Application by Medworth CHP Limited for an Order Granting Development Consent for the Medworth Energy From Waste Combined Heat And Power Facility

Issue Specific Hearing 1 (ISH1)

Action Points

LAND PLAN SHEET 13 OF 17

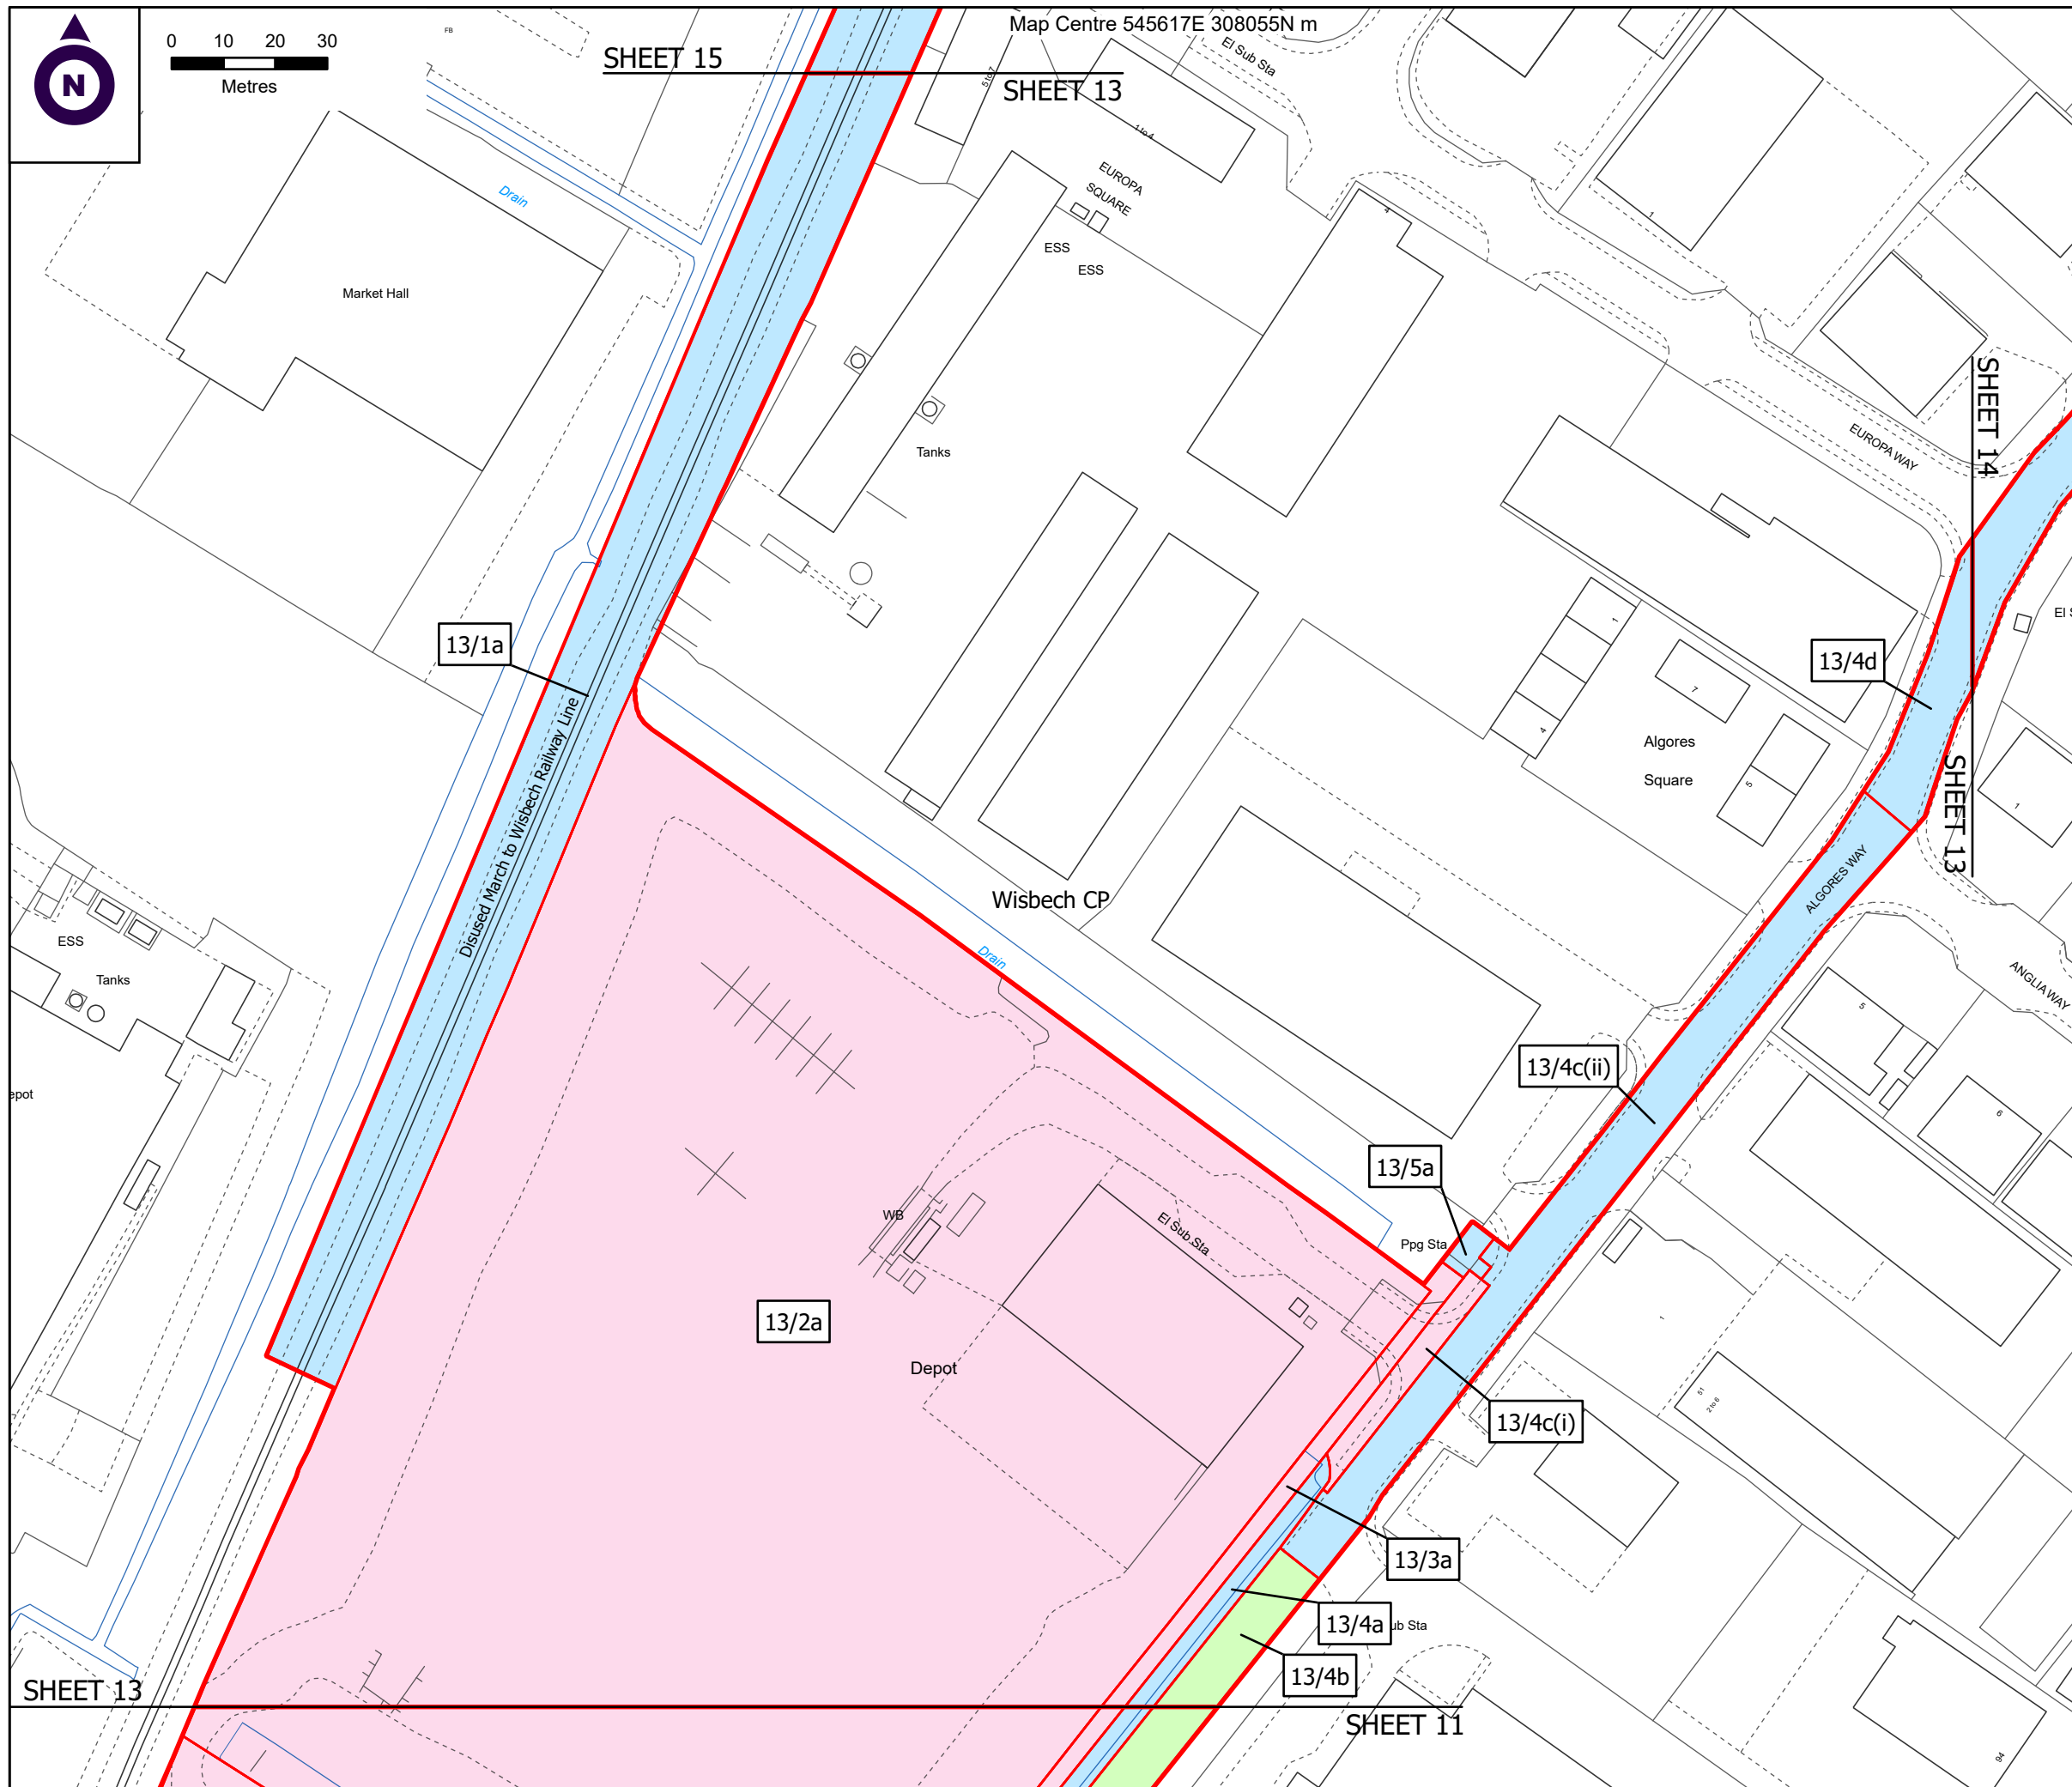
ISH1-AP5	Cambs. County Council (CCC)	To provide confirmation of their position in relation to the unadopted section of Algores Way which corresponds to plots 13/4c, 13/4d and 14/a of the Land Plan [AS-004].	Deadline 1 10 March 2023
ISH1-AP6	Applicant	Assuming CCCs position in relation to Algores Way is confirmed by Deadline 1 (see action 11), Applicant is requested to consider updating the Land Plan [AS-004] in order to	Deadline 2 24 March 2023

Ref	Party	Action	Deadline
		clarify the rights sought over the land plots 13/4c, 13/4d and 14/a.	
ISH1-AP7	Applicant	Provide the ExA with evidence and written narrative in relation to its consultation process with particular reference to any consultation carried out which specifically targeted businesses that rely on Algores Way for access and clarification of how these businesses are identified in the Book of Reference (BoR).	Deadline 1 10 March 2023
ISH1-AP8	Applicant	Submit updated version of the BoR following from a review of the Relevant Representations (RRs) received or diligent inquiries carried out by the Applicant and to highlight any additions to the BoR.	Deadline 1 10 March 2023
ISH1-AP9	Applicant, IPs, Statutory Parties and any Other Person	<p>Post-hearing submissions including written submissions of oral cases as heard on <u>ISH1</u>, including, but not limited to:</p> <ul style="list-style-type: none"> • Cllr Steven Tierney (Wisbech Town Council) to include link to the article quoted at ISH1 in relation to comments made by Green MEP Molly Scott Cato in relation to Energy from Waste Facility in Plymouth; • Dr. Clive Ballard, why the methodology used is not robust or transparent, particularly in relation to carbon impact calculation and why it does not necessarily align with the relevant literature; • Mr. Shlomo Downen (UKWIN) previous requests addressed to the Applicant in relation to the Climate Change Modelling Data Spreadsheets and revised WFAA; • Ms. Emma Barnett (Wisbech Town Council) comments in relation to Waste Fuel Availability Assessment and the suitability of a 2-hour catchment areas; • Cllr. De Walley (Borough Council of King's Lynn and West Norfolk), comments in relation to Item 5 of the ISH1 Agenda – Alternatives. 	Deadline 1 10 March 2023
